5. **Project# 1008915**  
12DRB-70265 EPC APPROVED SDP  
FOR SUBDIVISION

Project #: 1008915 Application #: 12 DRB-70265  
 Project Name: St. Joseph Hospital Complex  
 Agent: The Hartman & Majewski Design Group Phone #:

On July 12, 2012, the Environmental Planning Commission (EPC) approved Project #1008915/12EPC 40031, an amendment to a site development plan for subdivision for all or a portion of Lots 1A and 2A, St. Joseph Hospital Complex, located on Elm St., between Martin Luther King Jr. Ave. and Fruit Ave., containing approximately 14 acres.

Re: **Lots 1A and 2A, St Joseph Hospital Complex**  
**Martin Luther King NE between Walter Street NE and I25 Frontage Road**  
Request for DRB Approval- Site Development Plan for Subdivision  
COA Project #1008915, 12EPC 40031

SHEET NUMBER  
**L-101**

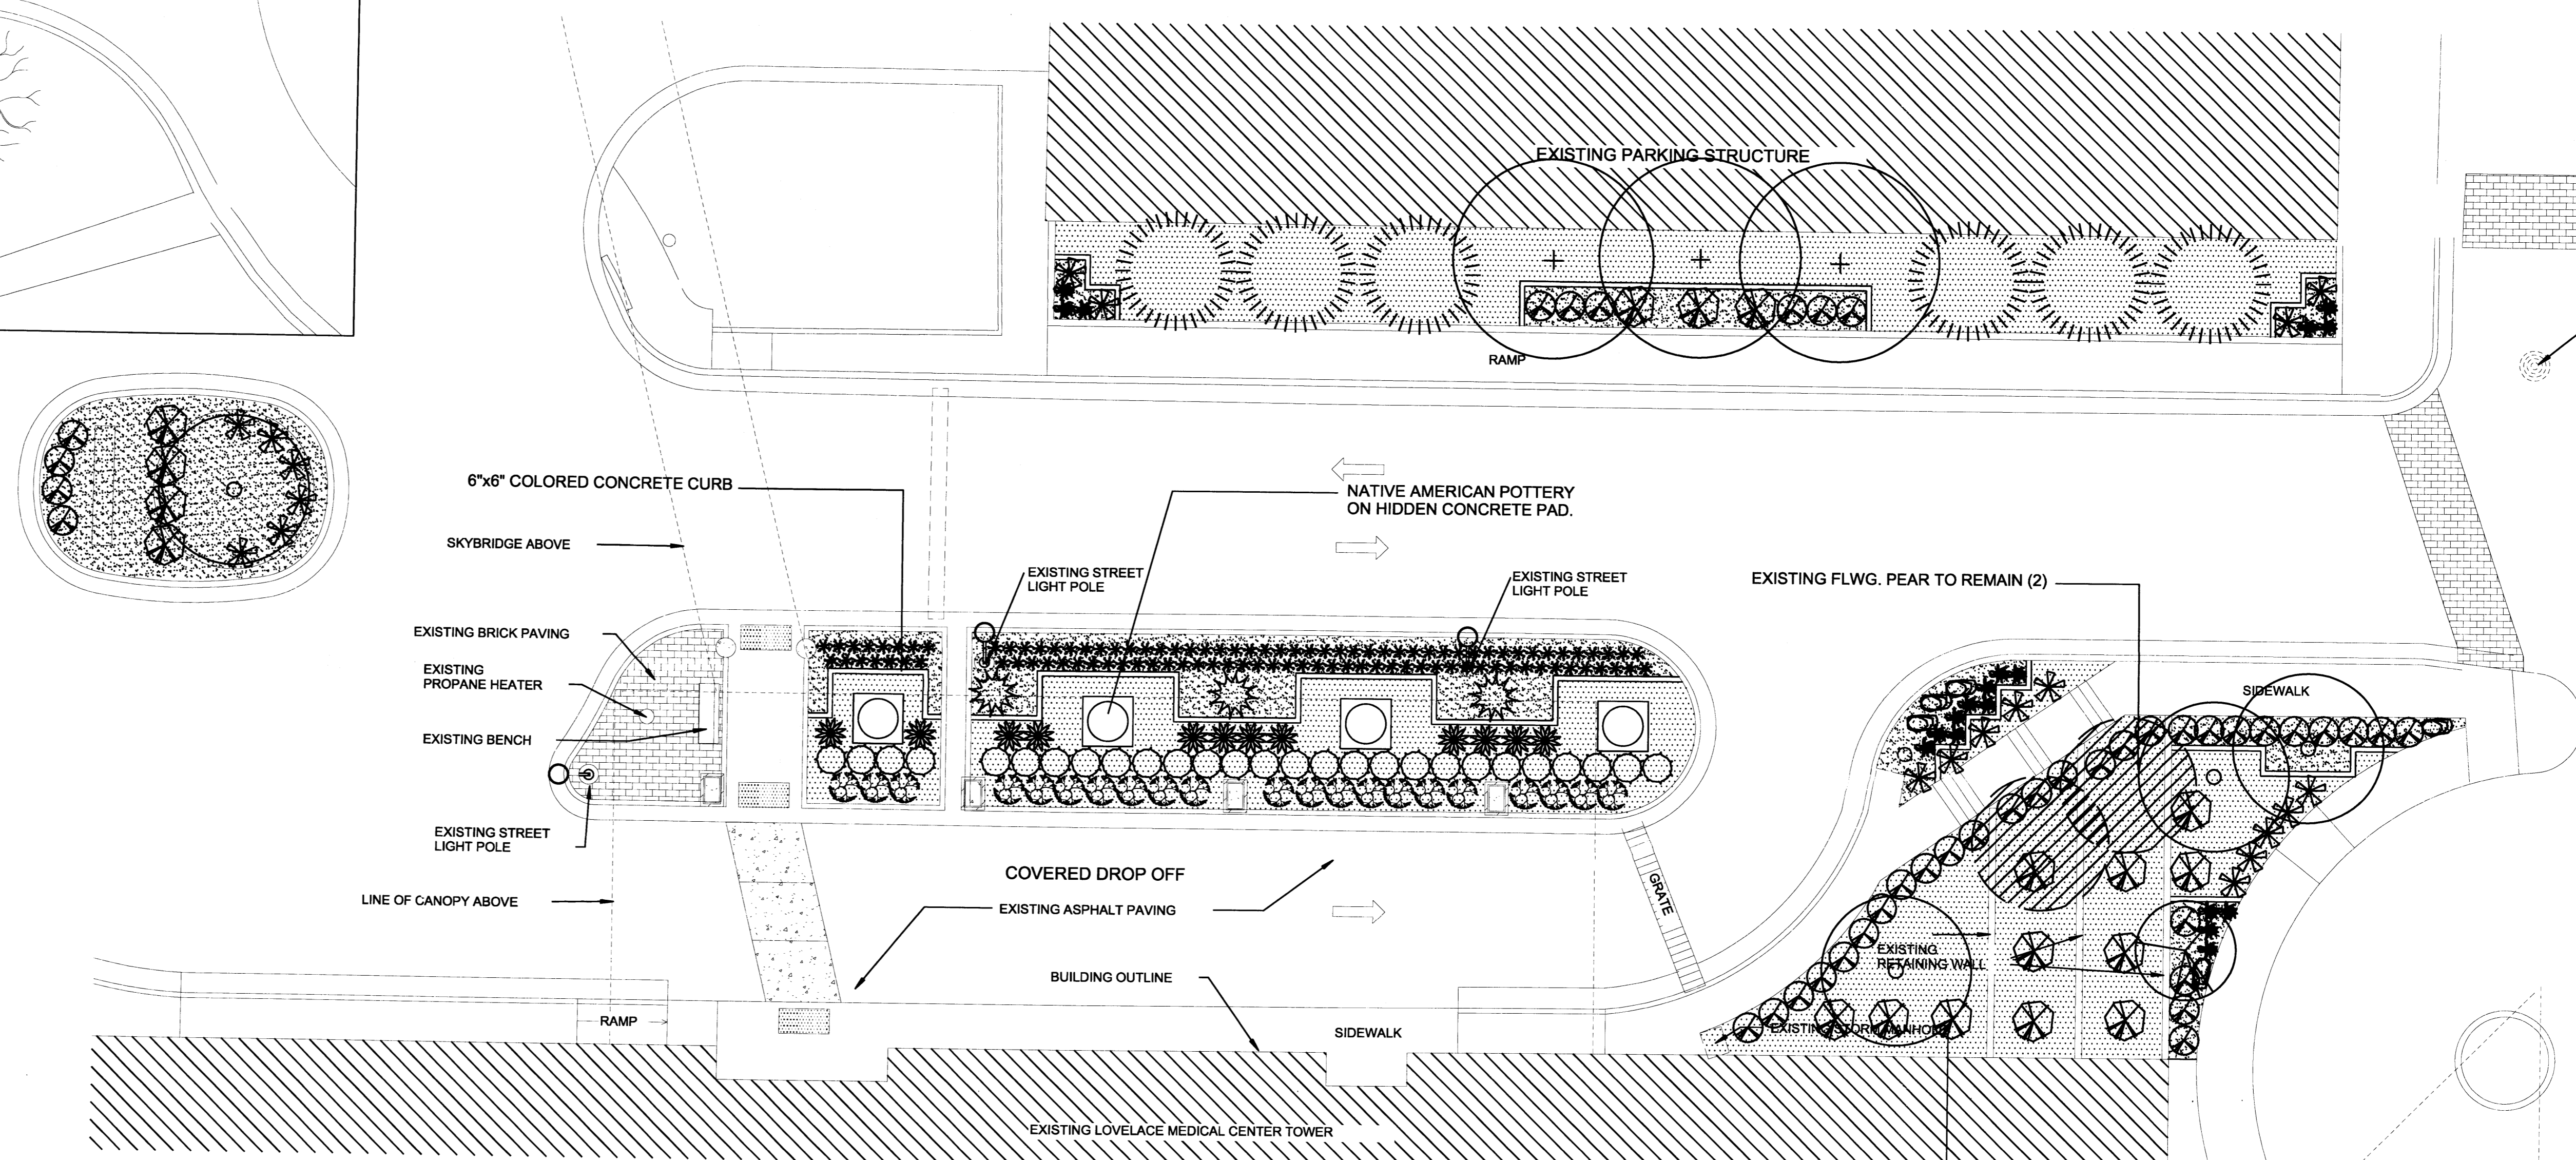
Where possible the proposed Landscaping will be consistent with the palette of the existing campus. Because this is a north side and shaded by the canopy many existing plants would not thrive. The proposed plan is a mix of existing plant species as well as new varieties that will perform well in the shaded conditions. We feel the proposed plan will provide a lush landscaping and meets the intent of matching where possible.

The mature plant sizes of the plans have been added to the landscaping plan.

We have added a detail for the entrance from Walter Street into the driveway of the campus. Coniferous trees will be added to help screen the valet drop off area and other vehicular activities from the neighborhood to the west.

**A1 SIGN DETAIL #1**  
 NOT TO SCALE

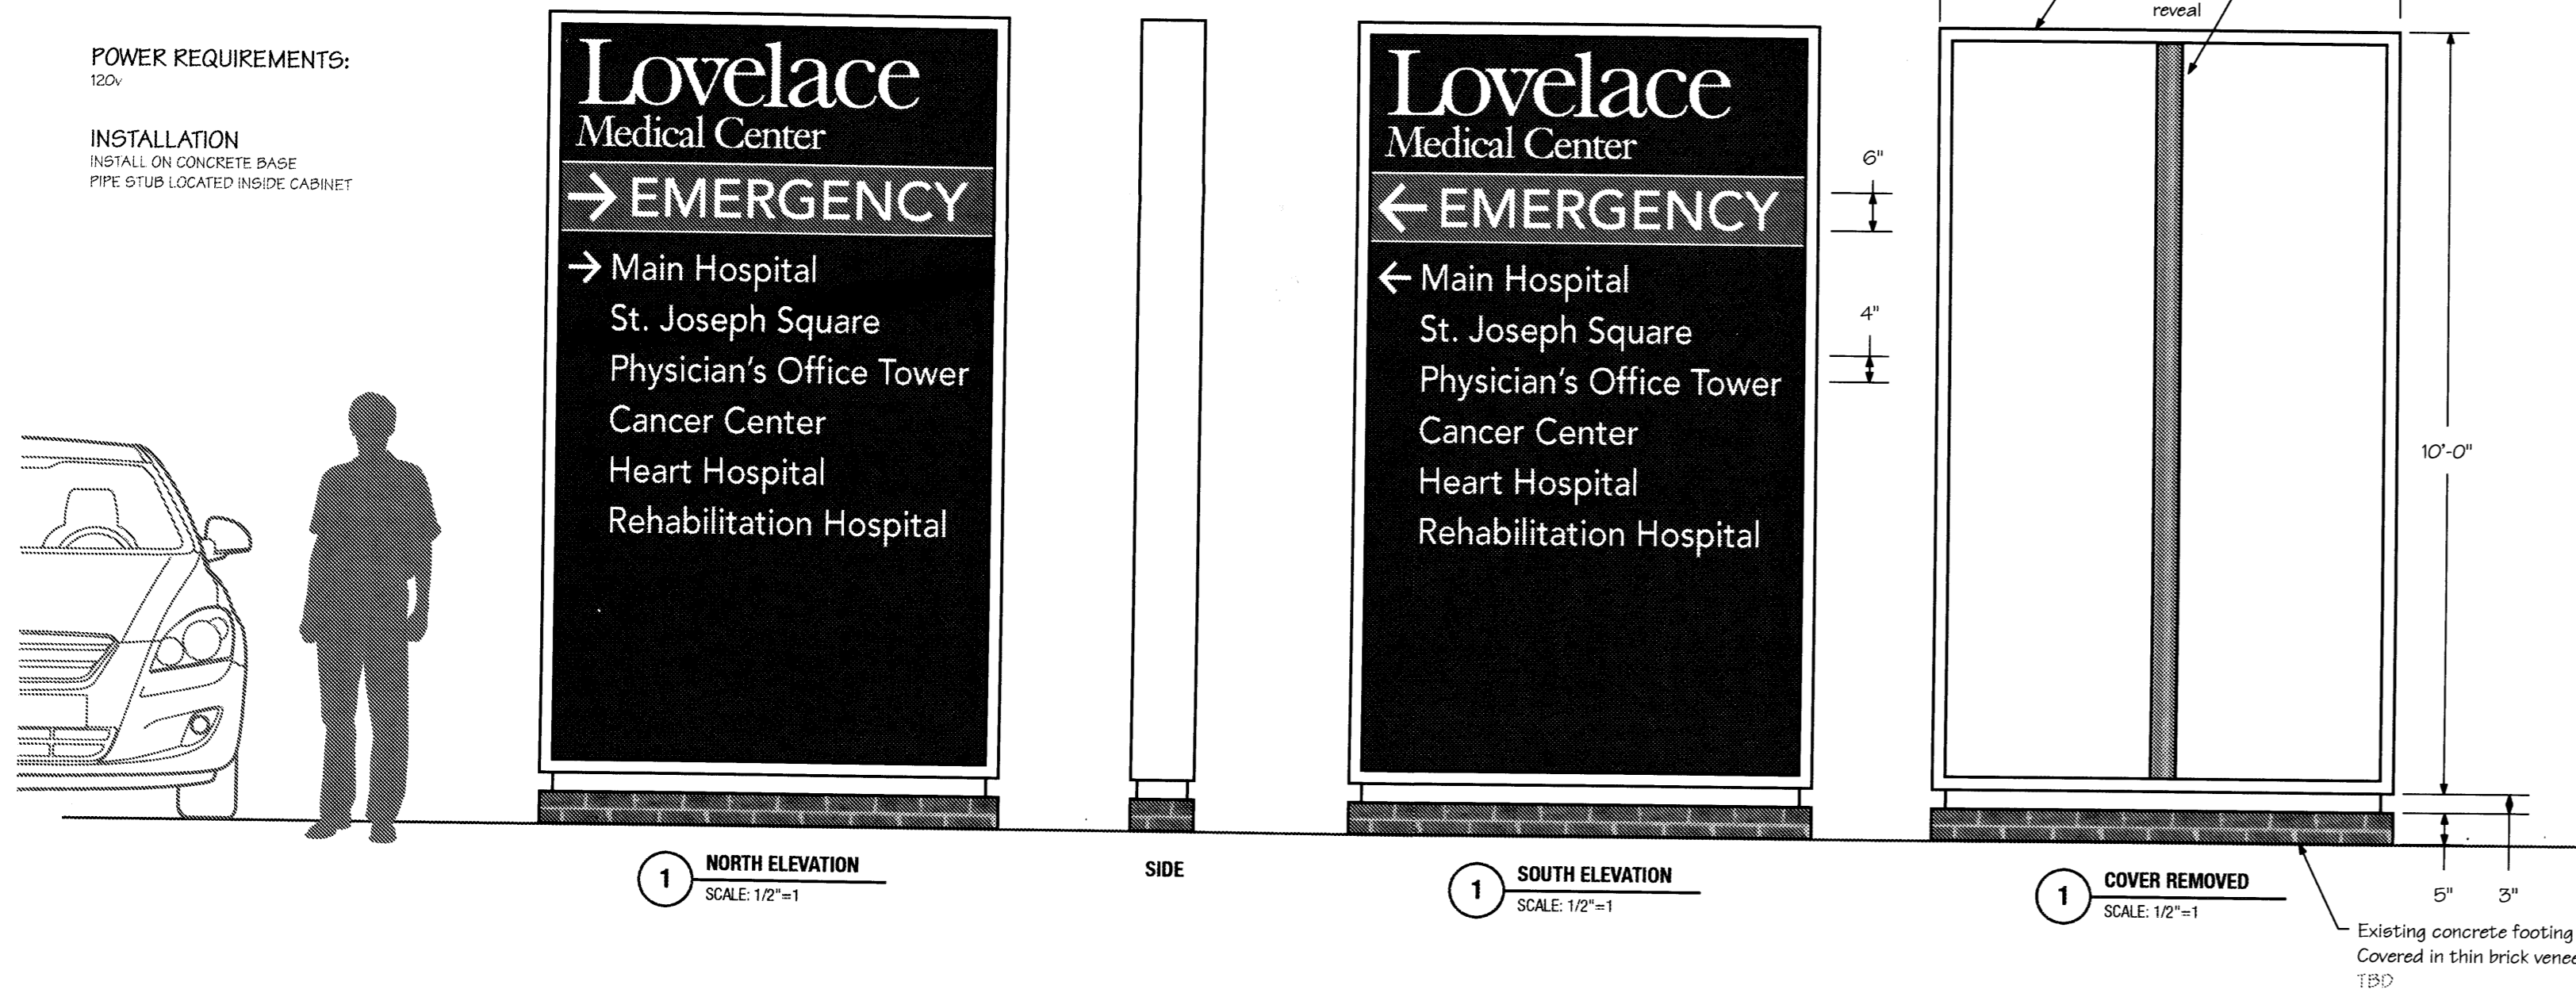
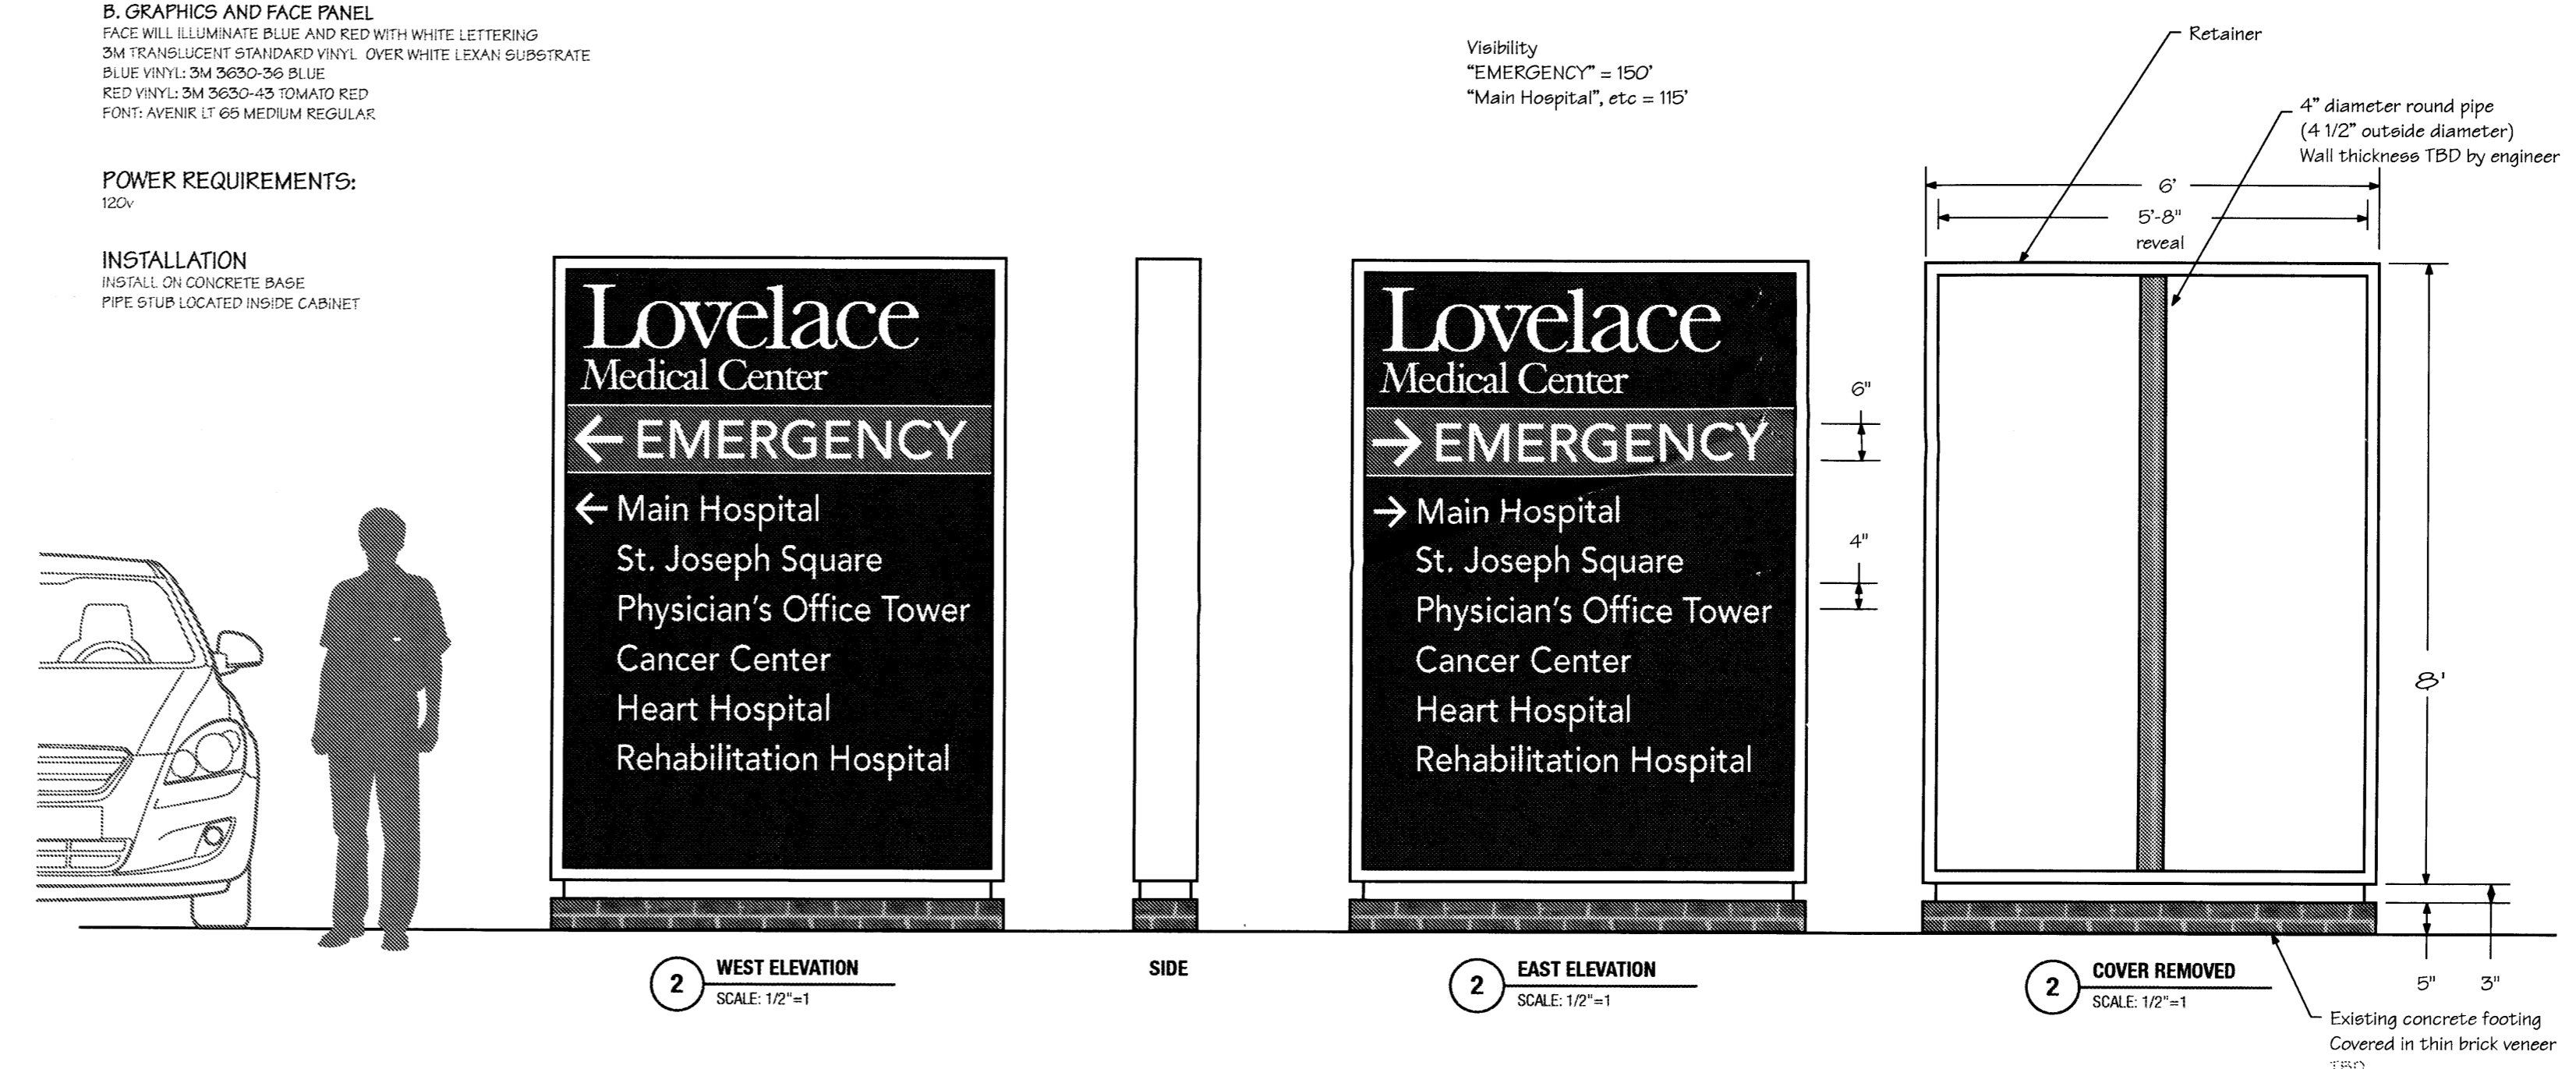
Sign at MLK and Elm Street NE will be reduced to 8' tall sign face.

A dimmer switch will be incorporated to allow for adjustment of the light output of the "MAIN HOSPITAL ENTRANCE" sign above the valet drop off area. The dimmer switch will be located up on the roof in a weather proof enclosure to restrict access and tampering with the setting.

This sign will be evaluated and relocated outside of the sight distance triangle or possible eliminated entirely.
